GOVERNMENT ARCHITECT NEW SOUTH WALES

10 March 2020

President Private Hospital
State Design Review Panel – Session 3
REV: Additional Landscape Advice

West Carpark Detail Plan

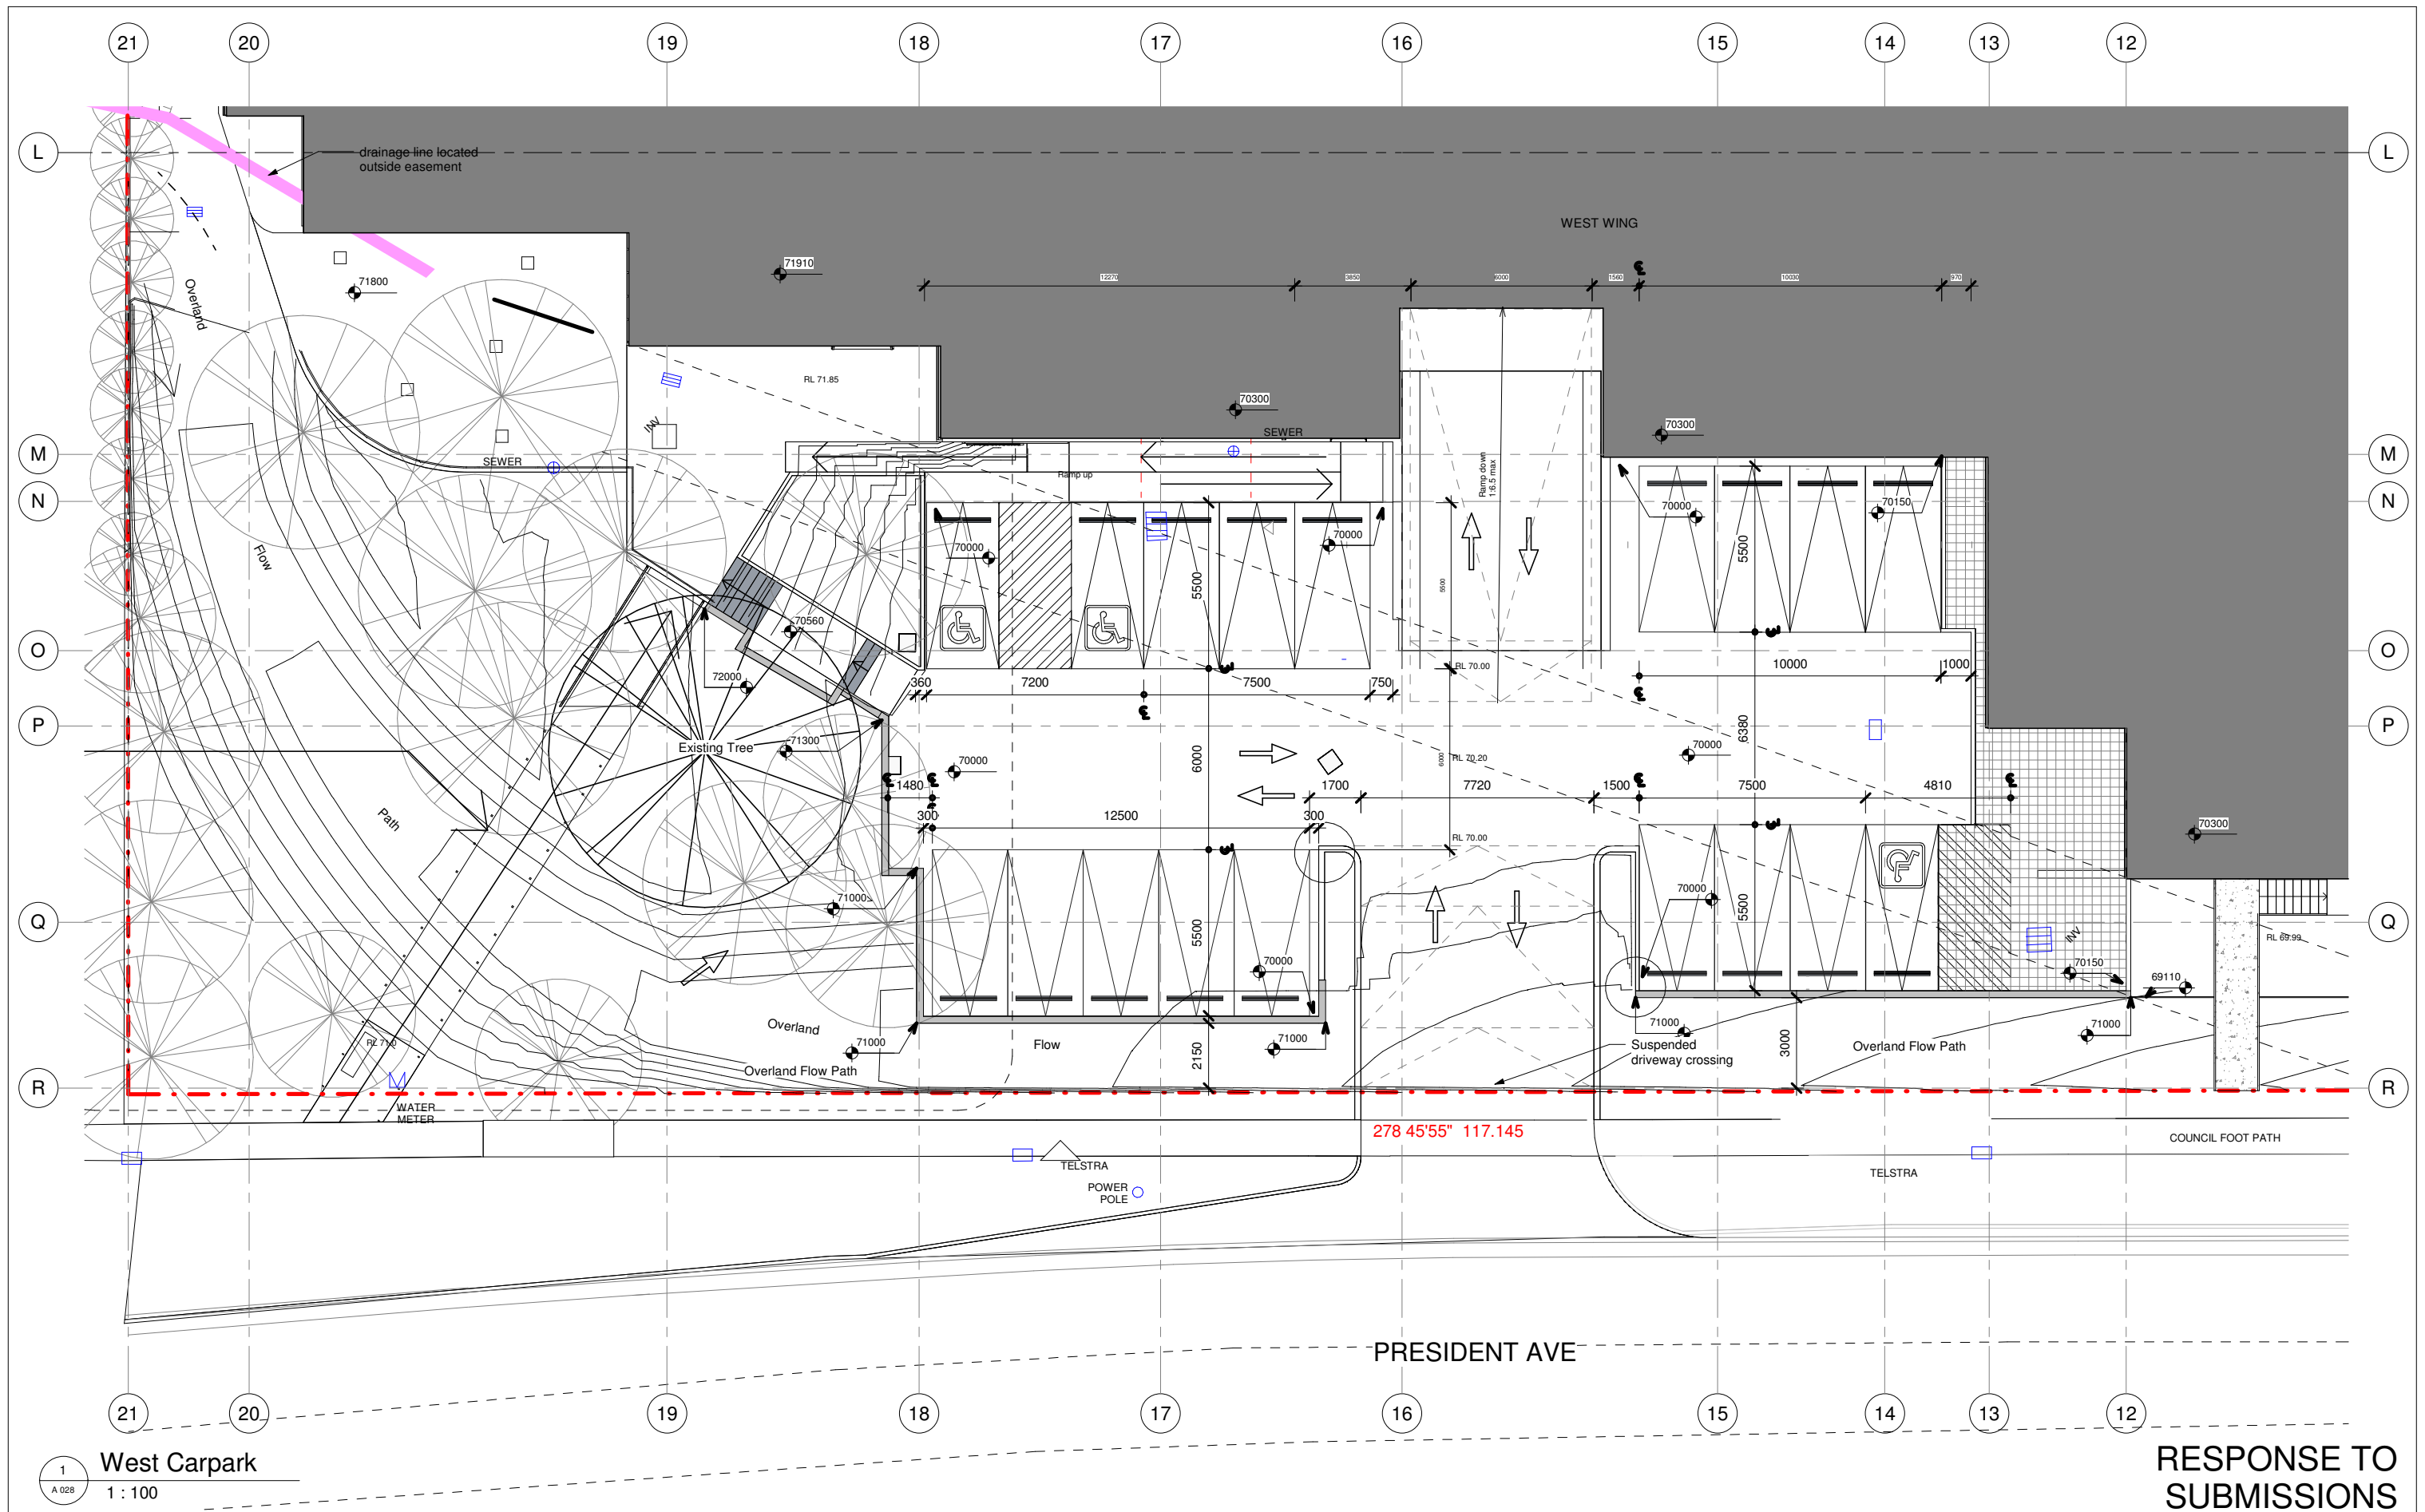
The voids to the carpark envelope visible from President Ave should be screened to mitigate headlight and lighting glare. A permeable treatment such as hit and miss brickwork may achieve this while remaining consistent with the proposed façade design.

HOTHAM HOUSE PARK - SECTION A-A
SCALE 1:150 @ A3

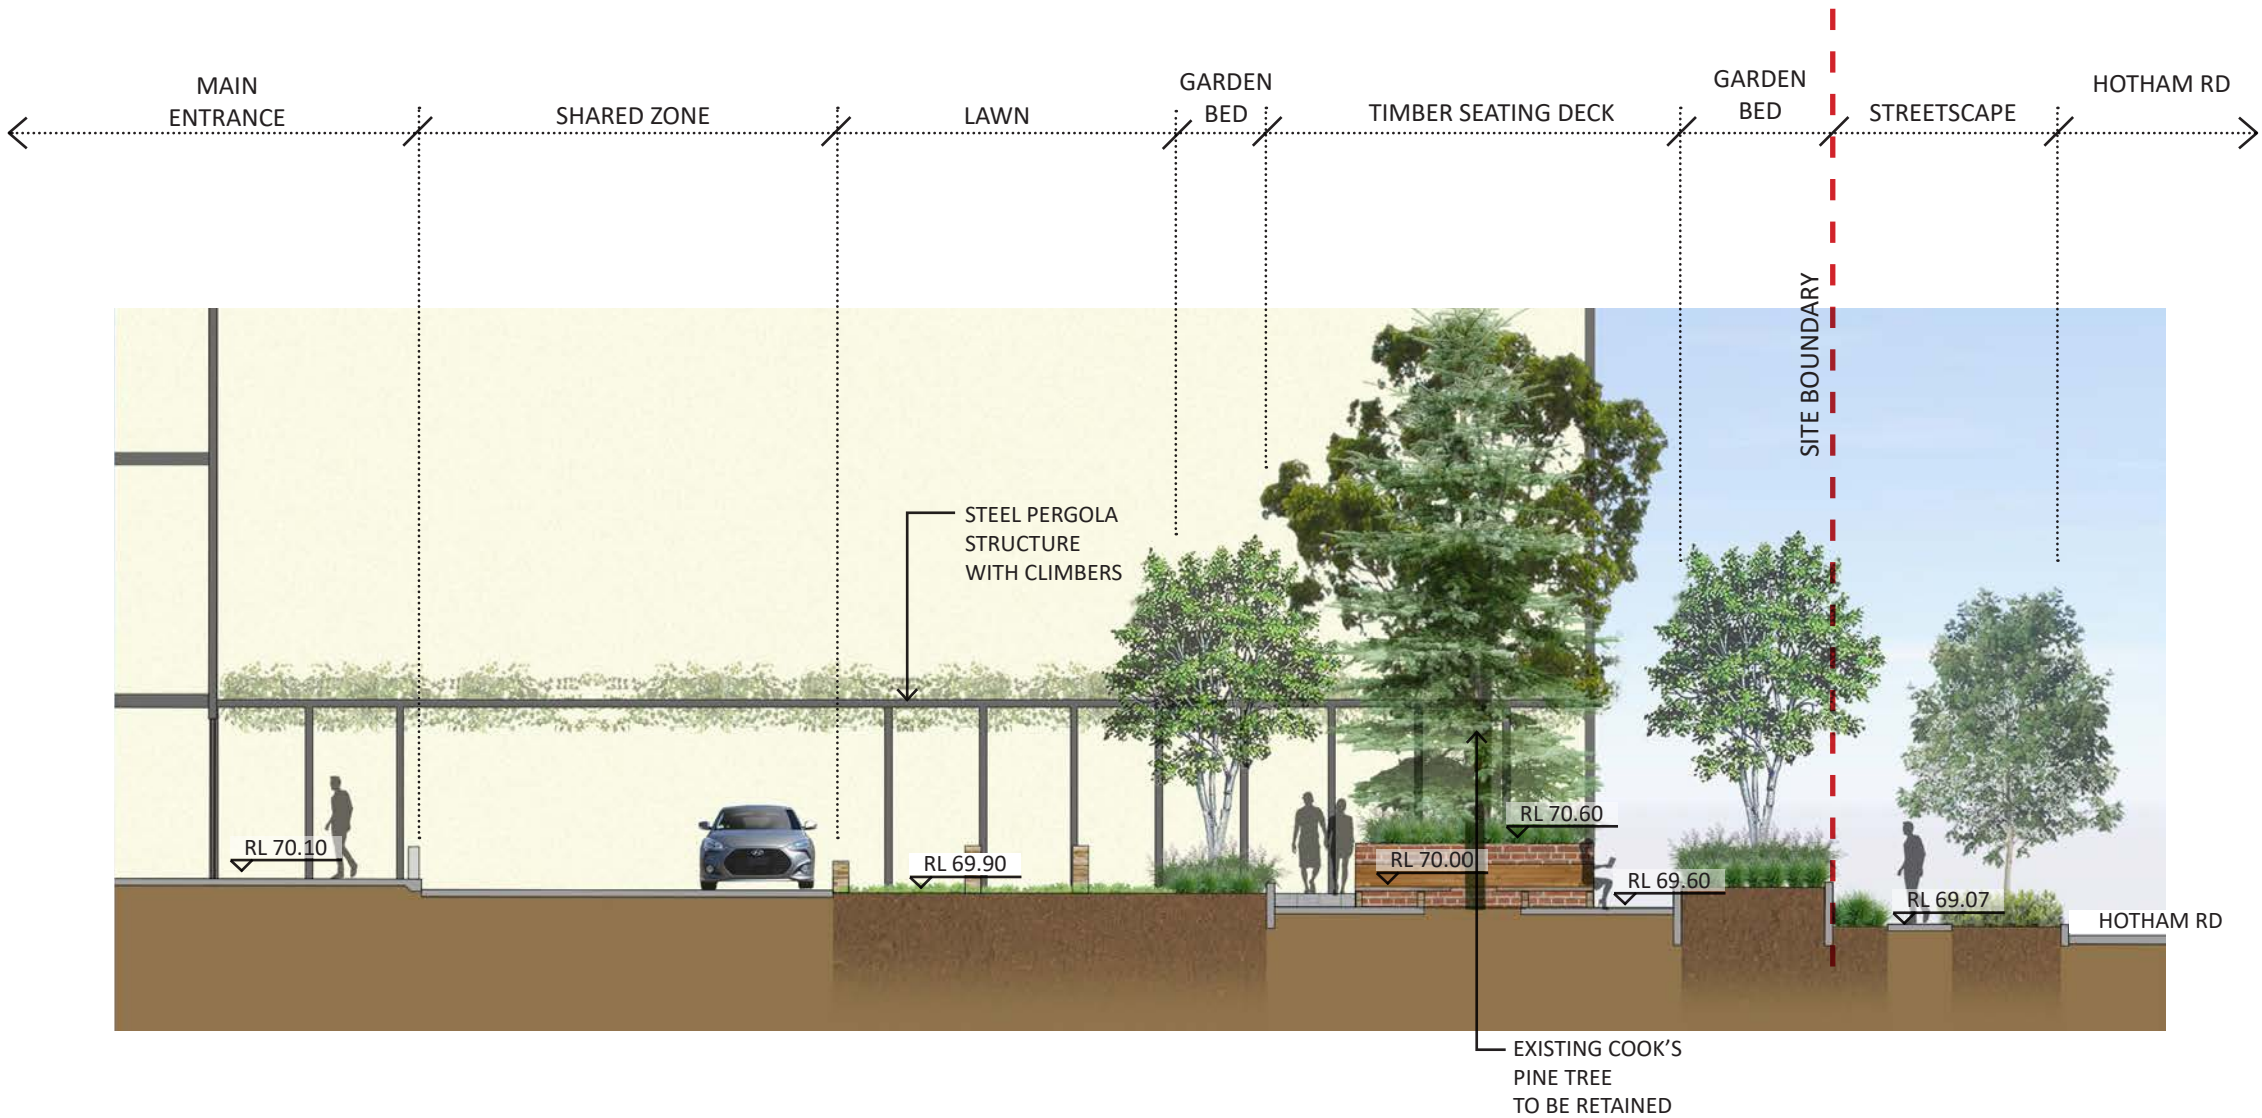
The latest landscape plans show removal of the tall Hoop Pine in Hotham House Park.

Retention of existing trees appears in SDRP 01 and 02 advice letters and specific discussion around retention of the Araucaria took place in those sessions. The landscape plans at SDRP 02 showed the tree as retained with seating around the base of the trunk providing a focus in the Hotham House Park space. This approach was supported.

Although we neglected to discuss it in SDRP 03, I am writing to request that you provide reasoning behind proposing the tree's removal now.

While we acknowledge the tree post-dates Hotham House it's the panel's position, assuming the tree is healthy, that it is significant and has landmark qualities and must be retained.

Integrating heritage interpretation elements into Hotham House Park is supported - the re-use of sandstone foundations and recycled materials from the house within this space should be further explored in detail design. Engaging with a heritage design consultant may be beneficial at this stage.
